From: [Maria O'Donnell](#)
To: [Emily Dickson](#)
Subject: SSD 6746 - MOD 1 - UTS Blackfriars Precinct Research Building - Response To Submissions - City of Sydney Council
Date: Friday, 29 March 2019 1:40:21 PM
Attachments: [image001.jpg](#)

Thank you for the opportunity to provide a response to the proponent's Response to Submissions. The City have now had the opportunity to review the details and make the following comments for your consideration:

Drawing Title
UTS BLACKFRIARS CAMPUS CB23
**A17 - DETAILED SHADOW
ANALYSIS - 2**

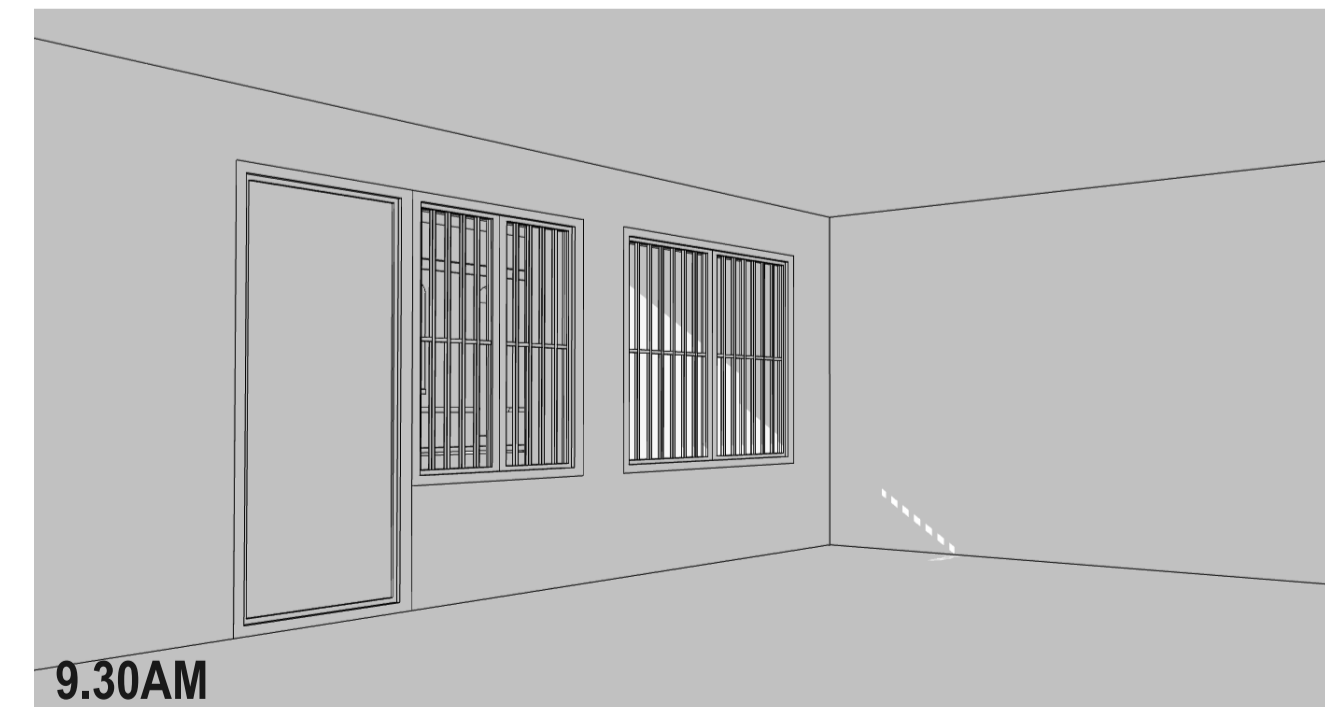
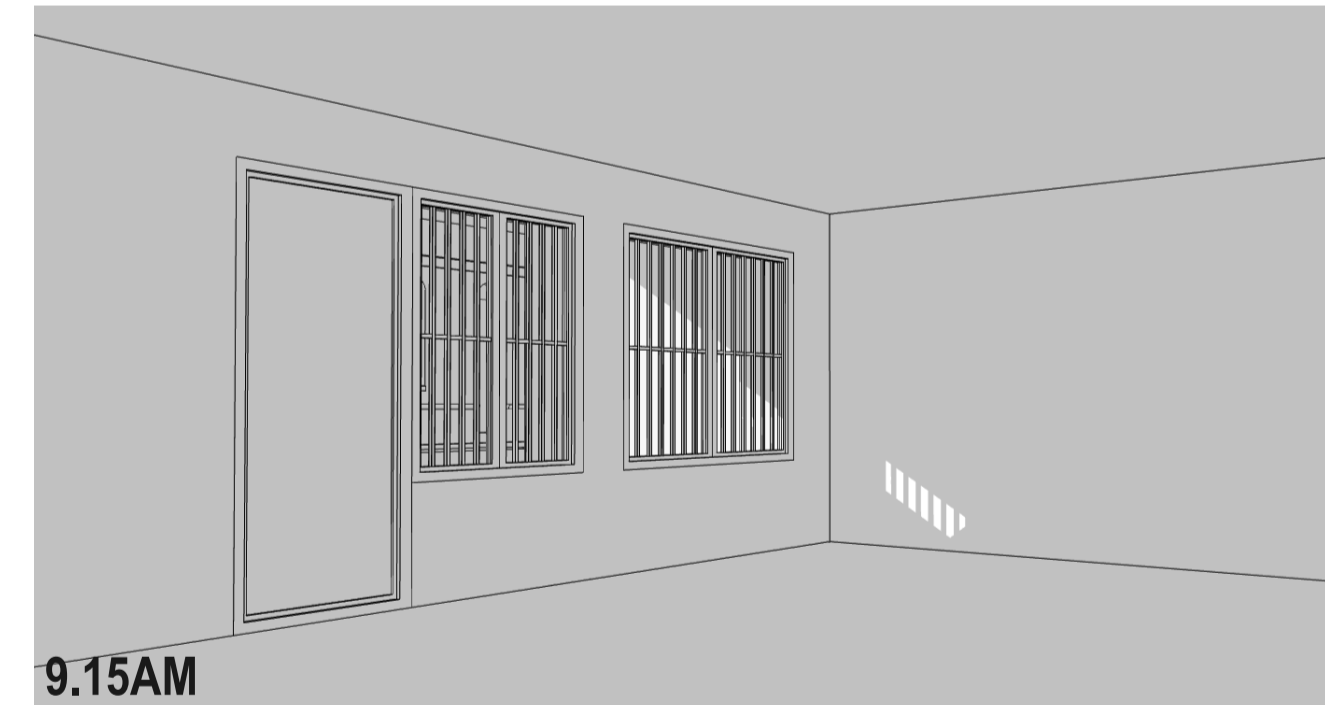
- With respect to overshadowing, Sydney DCP 2012 is the relevant document for guidance not the Apartment Design Guide. Where solar access is limited in dense urban sites, the City's controls aim to improve amenity to residential properties through the inclusion of habitable rooms as well as living spaces and private open space. The controls demonstrate the benefit of preserving sunlight to habitable rooms, where the design of living room glazing and private open space is otherwise inadequate. For occupants within these apartments, sunlight in a bedroom is as useful as sunlight to a living space. The setback dimensions have been carefully considered against other issues in the Stage 1 concept application, which resulted in the approved setbacks along Buckland Street. It is the City's view that any reduction in setbacks along Buckland Street reduces residential amenity of apartments in 2 Grafton Street and reduces the suitability of the apartments for residential use.

Drawing Title  
**UTS BLACKFRIARS CAMPUS CB23**  
**A02 - PROPOSED BUILDING ENVELOPE PLAN**

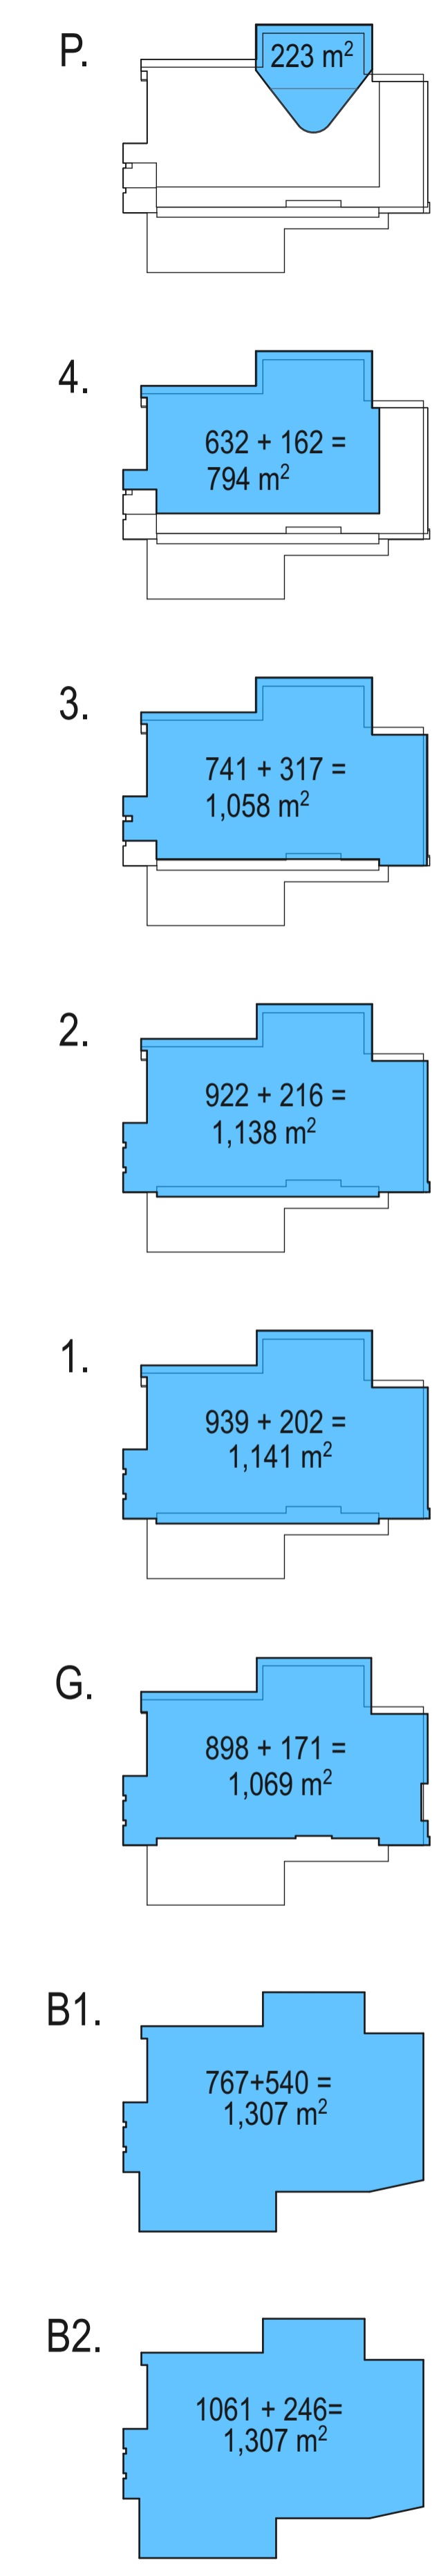
- Reference on the plan that the existing heritage fence is to be salvaged and restored is noted. However, proposed relocation of the gate pillars is not supported as it will alter the configuration of the fence and the gate's historical relationship with the surrounding streets.

- The amended plans now include a flood fence at RL 10.080 height behind the palisade fence and on top of the new retaining wall to protect the void and basement levels. The design detail and extent of the flood fence is not clear and based on what is shown, results in a poor design outcome. The addition of a defensive flood fence / barrier further reduces the heritage significance of the palisade fence and the significance of the landscape setting. The proposed design erodes the already compromised setback to the western boundary on Buckland Street.
